**Application by National Highways for
an Order granting Development
Consent for the Lower Thames
Crossing (Ref. No. TR010032)**

**Submission for Examination Deadline 1
– 18 July 2023**

**Emergency Services & Safety Partners
Steering Group (ESSP SG)**

Written Representation

# Mott Family Emergency Vehicle RVP Location

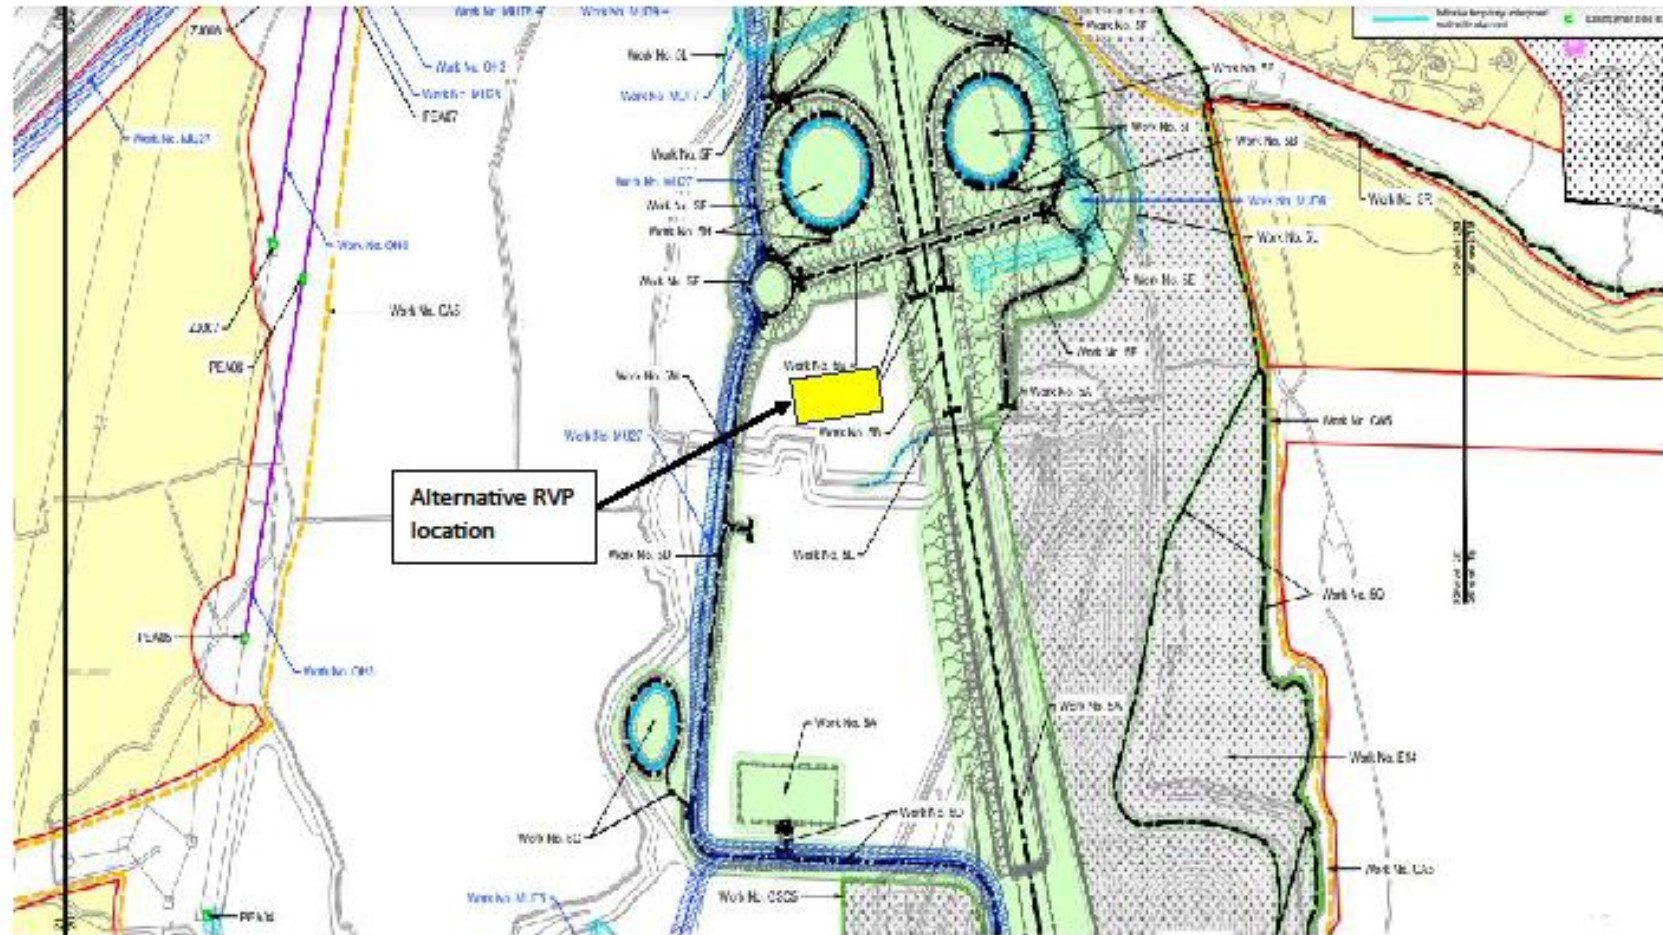
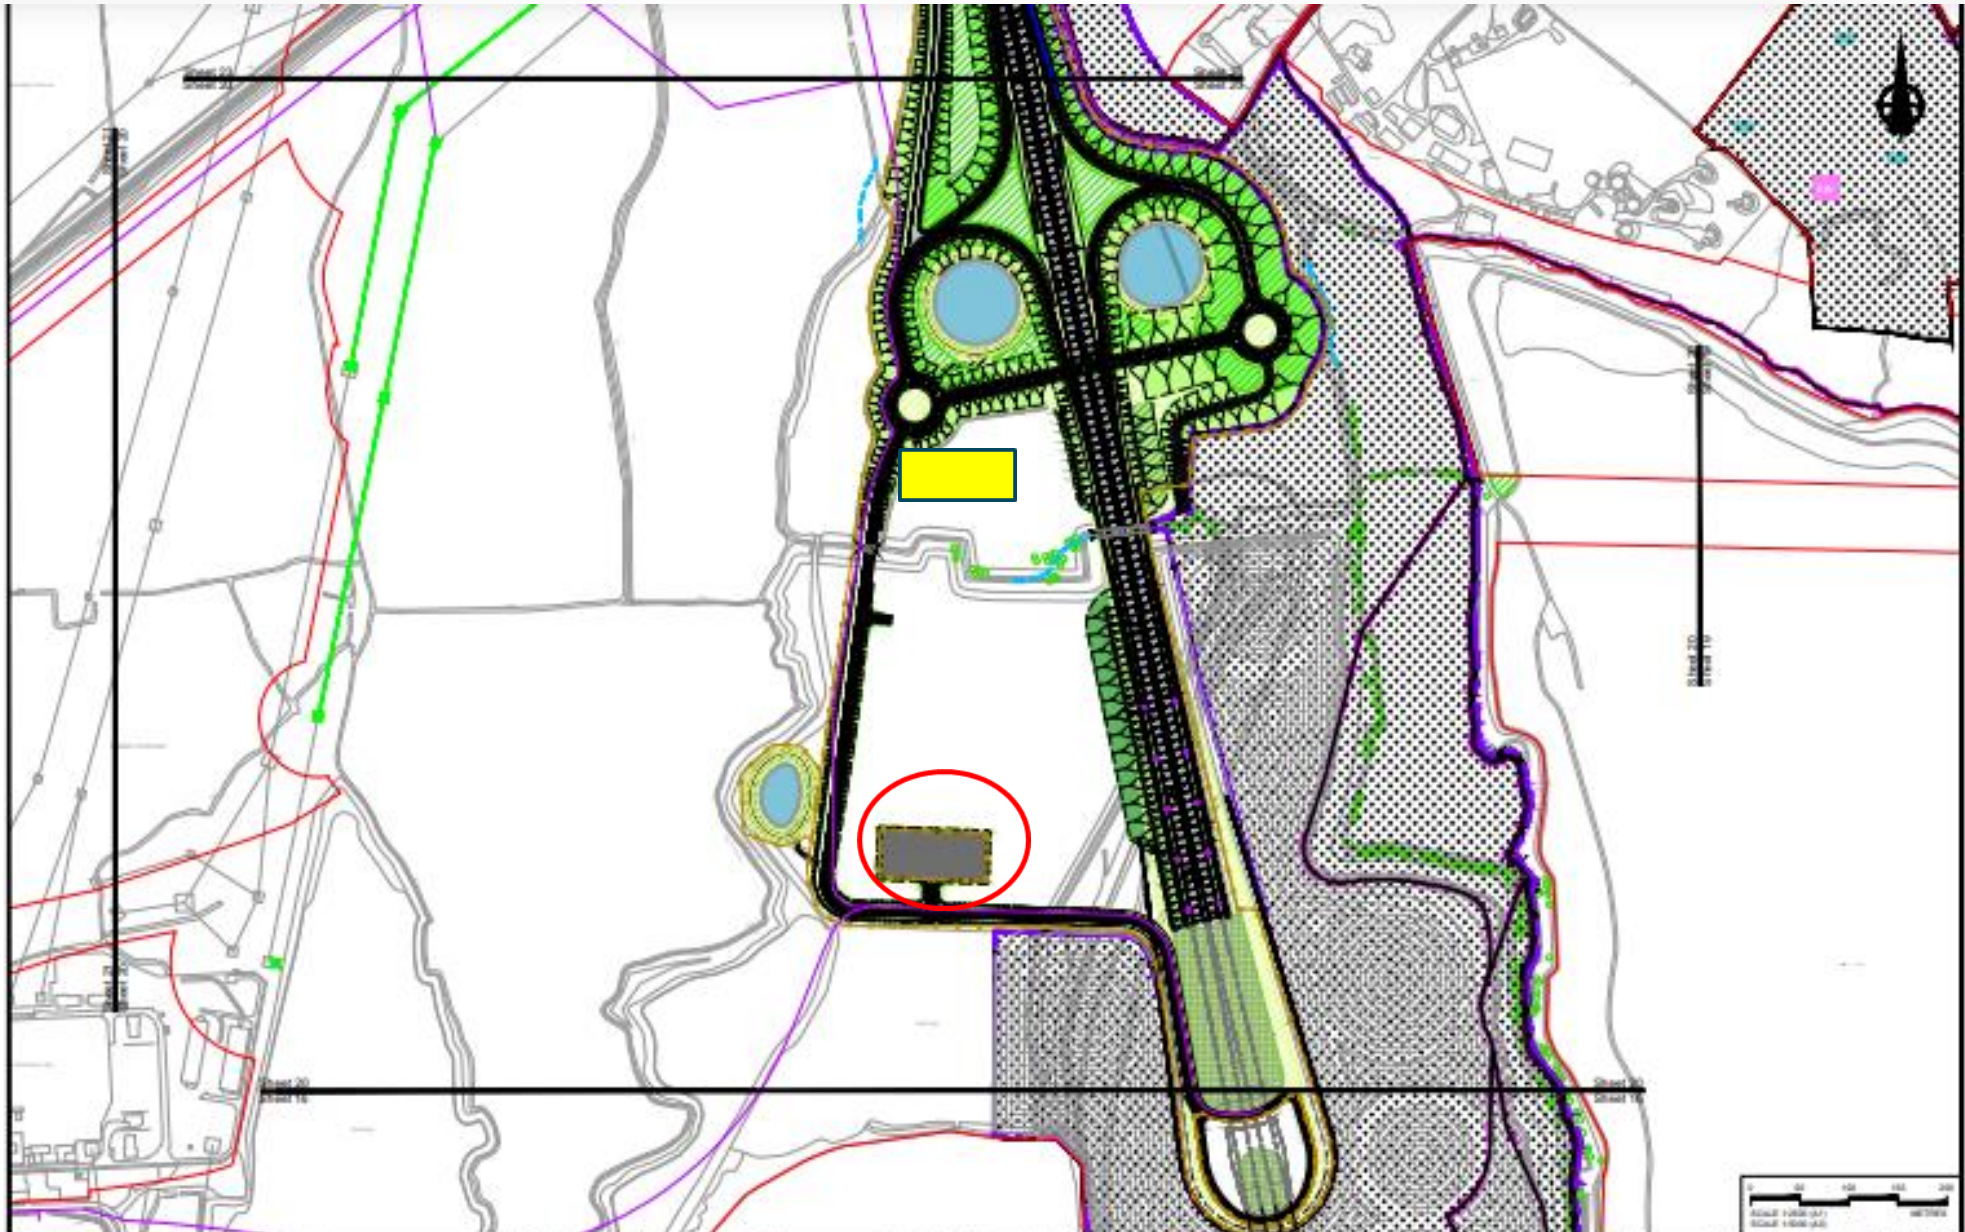
28. Emergency hubs are also shown on the scheme drawings. However, the following points are raised:
- a) the ESSP SG objects to the location of the northern RVP – this location is considered unsuitable, being too close to the tunnel portal. RVP locations should allow resources to muster ahead of the project, to receive briefing and direction in a position which will not be affected by any ongoing incident. It is not clear to ESSP SG how its advice in Annex B has been taken into account.

- b) the ESSP SG has concerns regarding the size of the RVPs – these should be large enough to house a small building, lighting, power and parking facilities for approximately 30 - 40 vehicles. It is not clear that this will be the case, particularly for the southern RVP, which is much smaller. No further detail has been forthcoming since issuing the advice contained in Annex B (particularly paragraphs 30 and 31).
